Present application 14/01384/OUT: including 2600 homes.

Masterplanning

BIMP6 108D Landscape parameters - open space strategy

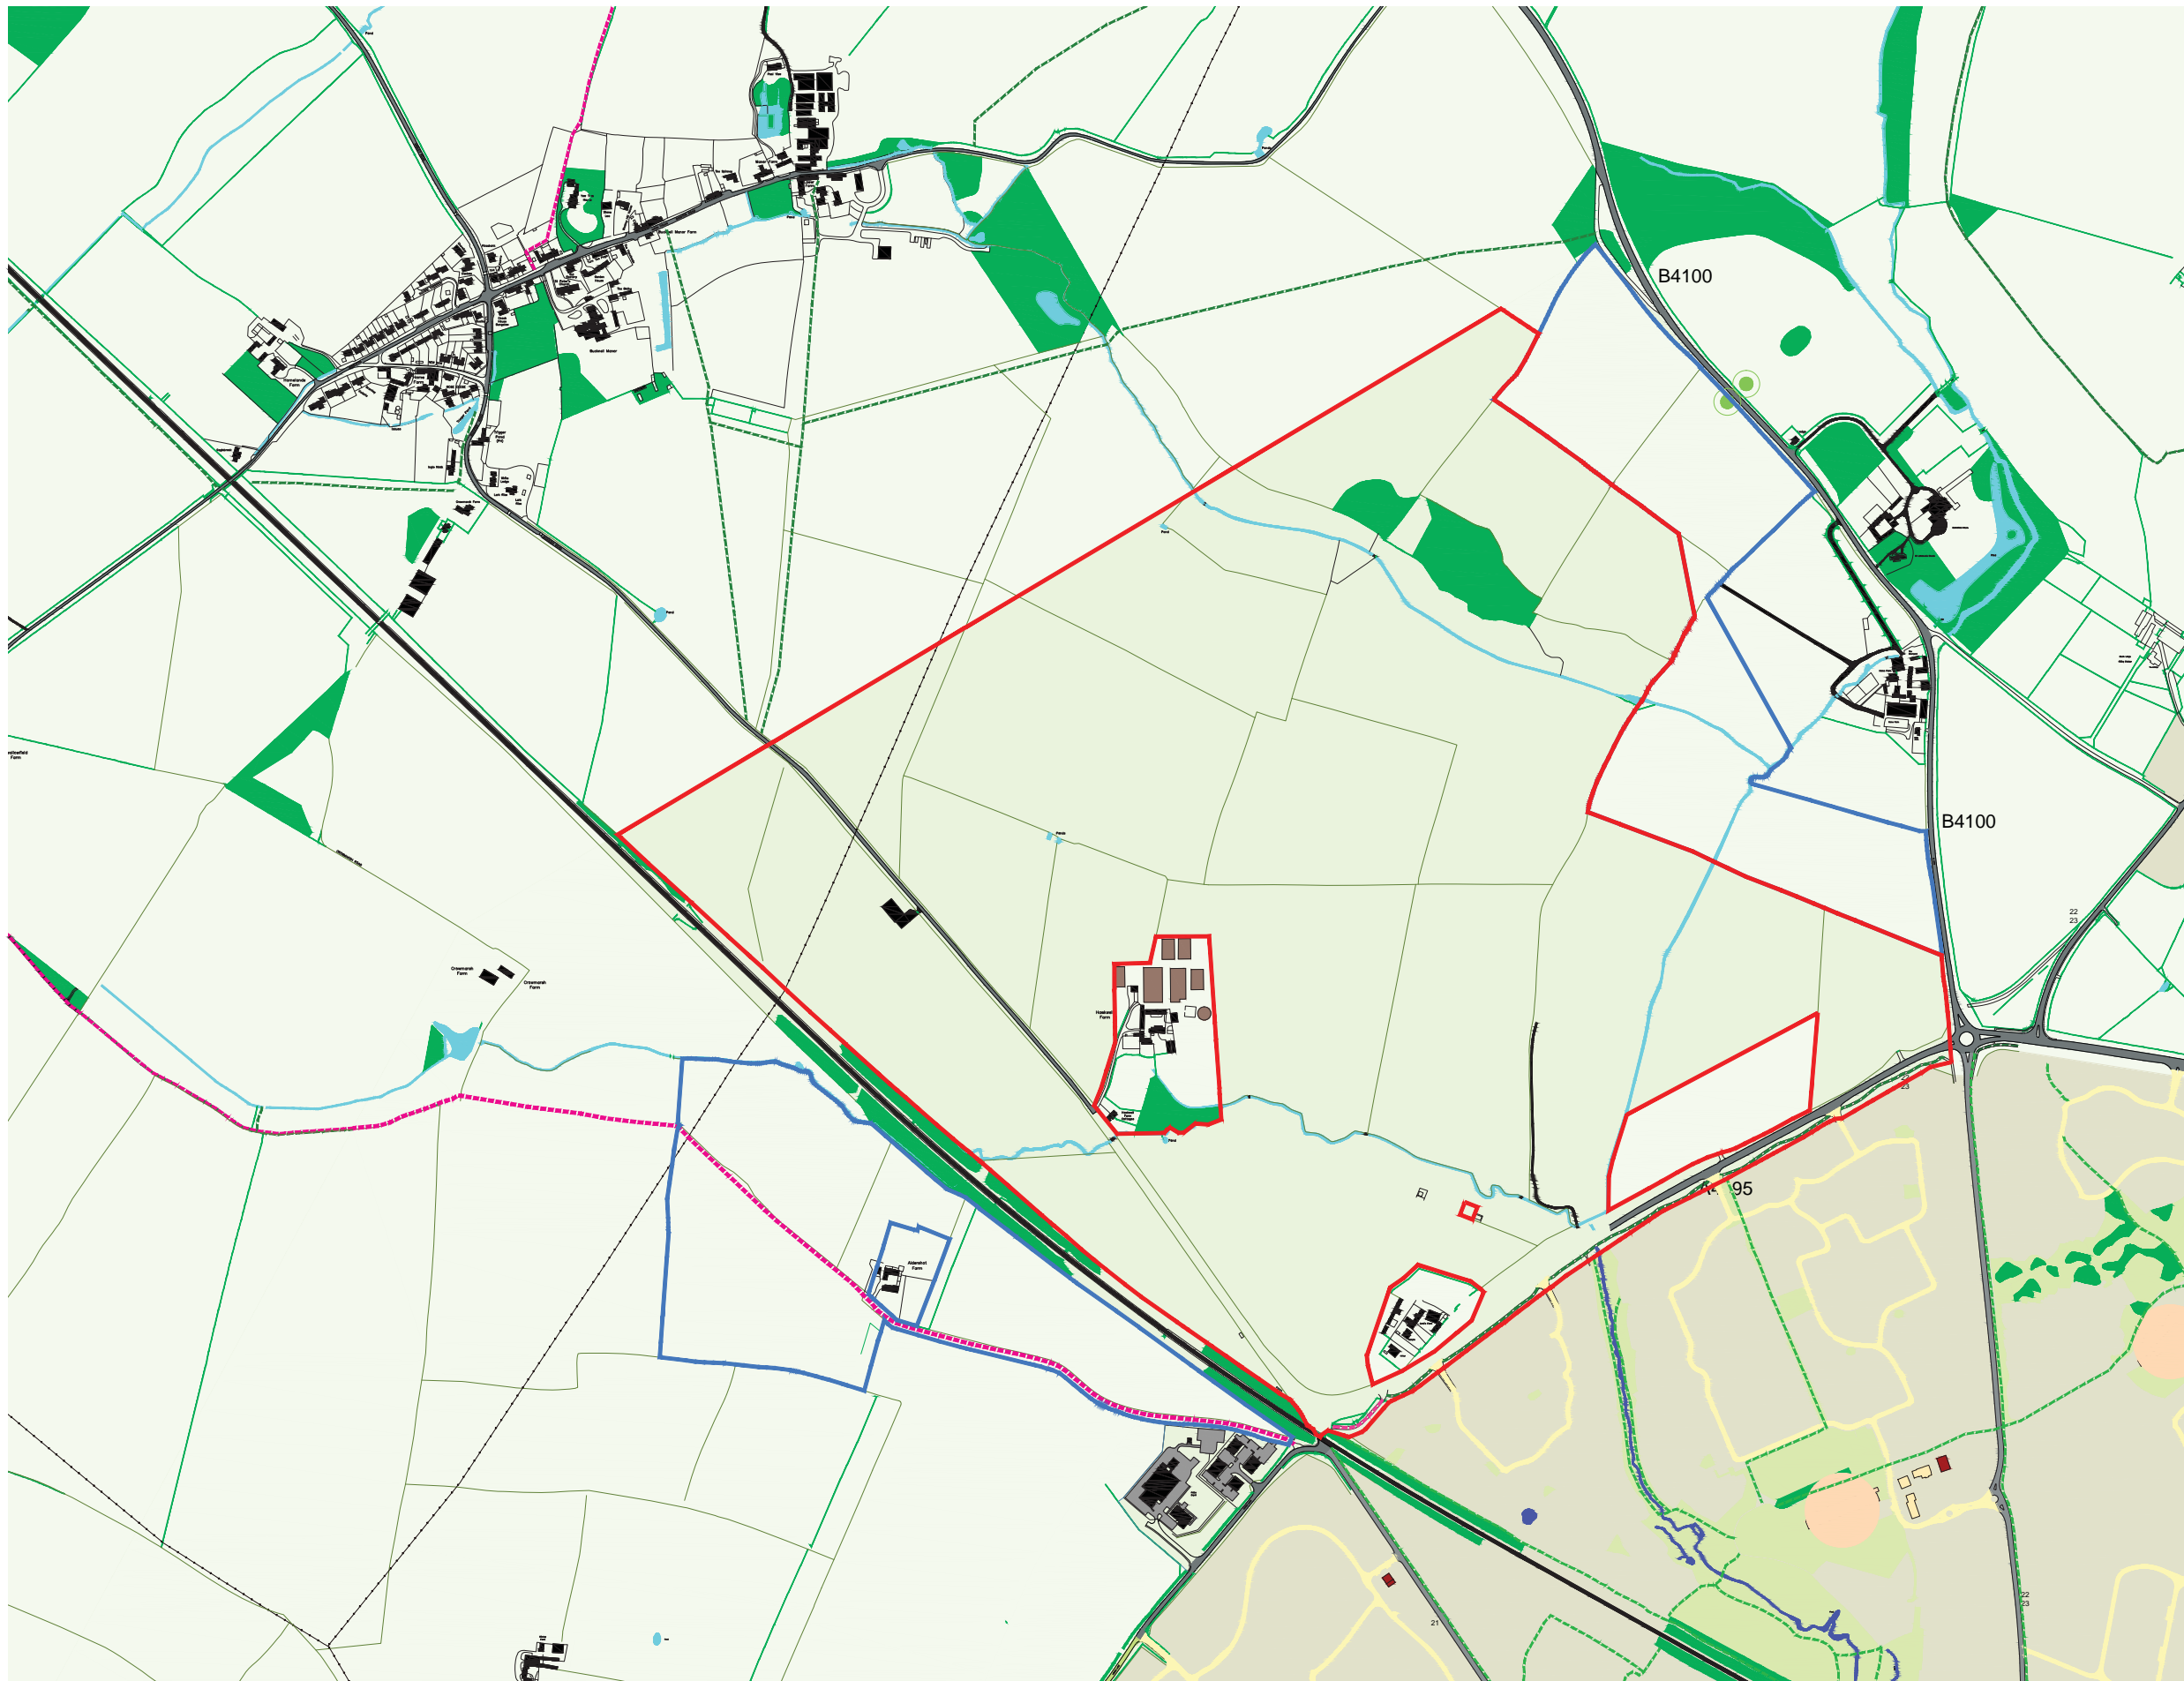
However, the application includes the draft SPDs masterplan framework for the whole North West Bicester site (BIMP6 01 rev A) and the submitted 'Parameter Plans' (BIMP6 116D, 100A, 106B, 107C, 108D, 109D, 110C, 111C, 113C, 116D) are generally consistent with the framework. Potential exceptions include the configuration of the school and playing fields at the western end of the site and the location of allotments which may require some clarification. These plans together with other supporting documentation with demonstrate how the
